RE: SSD-66876472 | BERRIMA HOTEL (The Berrima Quarter) — Response to Submissions

Martens and Associates (**MA**) have prepared this response to assist Blue Sox Group (the **client**) in addressing stormwater management comments in relation to the State Significant Development (**SSD**) application for The Berrima Quarter, 2-4 Argyle Street, Berrima NSW (the **Site**). Comments were received via a request for further information (**RFI**) from Wingecarribee Shire Council (**Council**) and WaterNSW.

The revised Concept Civil Works plan (P2410244PS01-R06) prepared by MA have been provided in Appendix A.

| DRAWING TITLE                                   |             |             |             |          |
|-------------------------------------------------|-------------|-------------|-------------|----------|
| P2410244                                        | PS01        | R06         | PS01-E700   | E        |

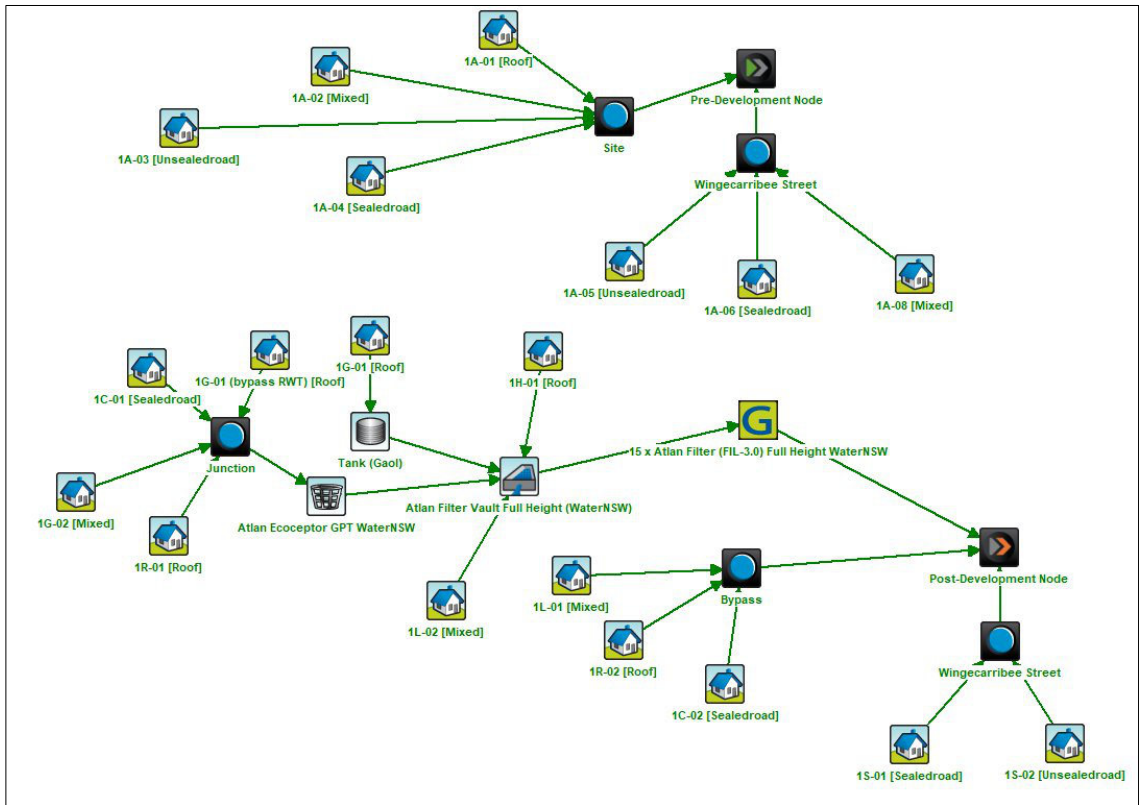
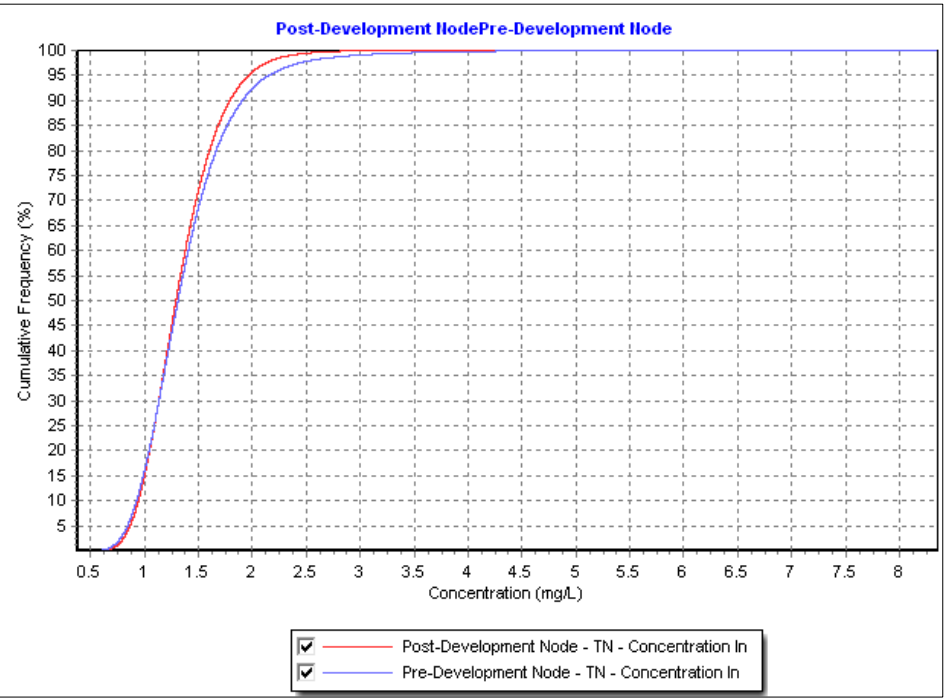
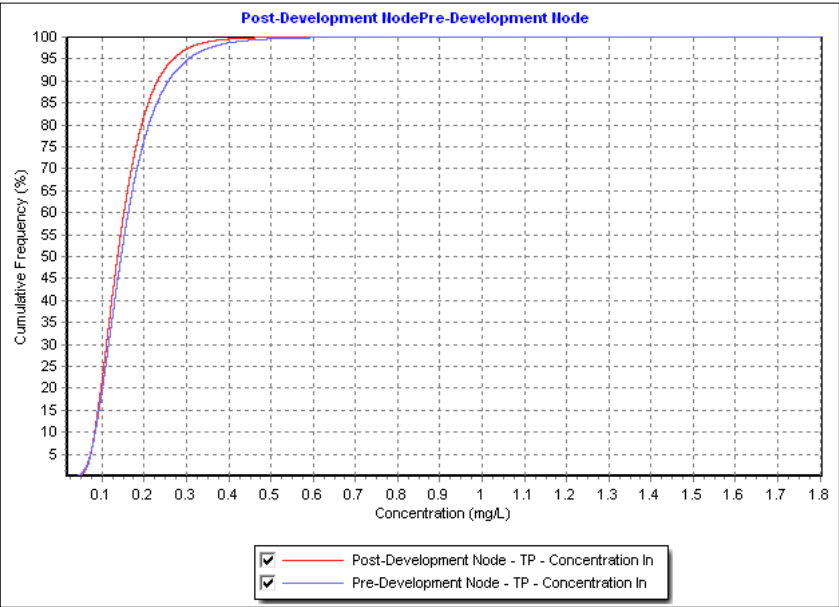
Agency Comments	MA Response
Council, 26 November 2025	
<i>Council recommends that the use of Vortex style Gross Pollutant Trap (GPT) in preference to filter cartridges to maximise treatment efficiency and reduce maintenance costs.</i>	(1) A vortex style GPT (Atlan Vortceptor) was tested in the MUSIC model as a replacement for the proposed filter cartridges. However, due to the lower pollutant removal efficiency of the vortex style device compared to the filter cartridges, a Neutral or Beneficial effect (NorBE) on water quality could not be achieved. The treatment for the devices in comparison for reference are: a. Vortex style GPT (Atlan Vortceptor): GP 98%, TSS 70%, TP 30%, TN 0%. b. Filter cartridge (Atlan Filter): GP 100%, TSS 75%, TP 40%, TN 25% For this reason, the proposed filter cartridges have been retained in the proposed design in order to achieve NorBE.

Agency Comments	MA Response
	Refer to the Concept Civil Works plan (P2410244PS01-Z00 and Z01) for the pre and post development comparison of the 1% AEP flood extent. Refer to Flood Impact and Risk Assessment prepared by MA for additional information.
<i>The Stormwater Management Plan demonstrates that water quality impacts from increased impervious areas on site can be managed via an 80,000-litre underground rainwater tank with 1,750 kilolitres per year reuse, proprietary gross pollutant traps, onsite detention basin and a treatment vault with fifteen cartridge filters. However, specific details for stormwater treatment and management from the Wingecarribee Street upgrade have not been provided.</i>	(7) It should be noted that a 100kL rainwater tank is proposed for reuse purposes. To account for overflow and sediment storage 80kL (80% of the total physical storage volume) has been adopted in the modelling in accordance with the Using MUSIC in the Sydney Drinking Water Catchment Guideline 2025. (8) Details of the proposed stormwater management works in Wingecarribee Street have been updated in the Concept Civil Works drawings and are summarised below: a. The proposed swale details are provided on Drawing E200, including batter slopes, vegetation, longitudinal grade, and design flows and velocities. b. The proposed pit and pipe long sections (invert level, pipe type, pipe grade and pit levels), pit schedules and drainage plan view are provided on Drawing E300 – E302 and E100 – E101. c. The proposed Wingecarribee Street extent of works, long sections and grades have been provided on Drawing C100 and D200. d. The proposed Wingecarribee Street pavement plan has been provided on Drawing G400. Further to the above, the MUSIC model has been updated to reflect the proposed works in Wingecarribee Street and demonstrates no additional treatment water quality treatment are required to meet Norbe requirements as the site is already overcompensated for treatment. For MUSIC catchment plan and results, refer to the Concept Civil Works plan (P2410244PS01-E700 to E701).
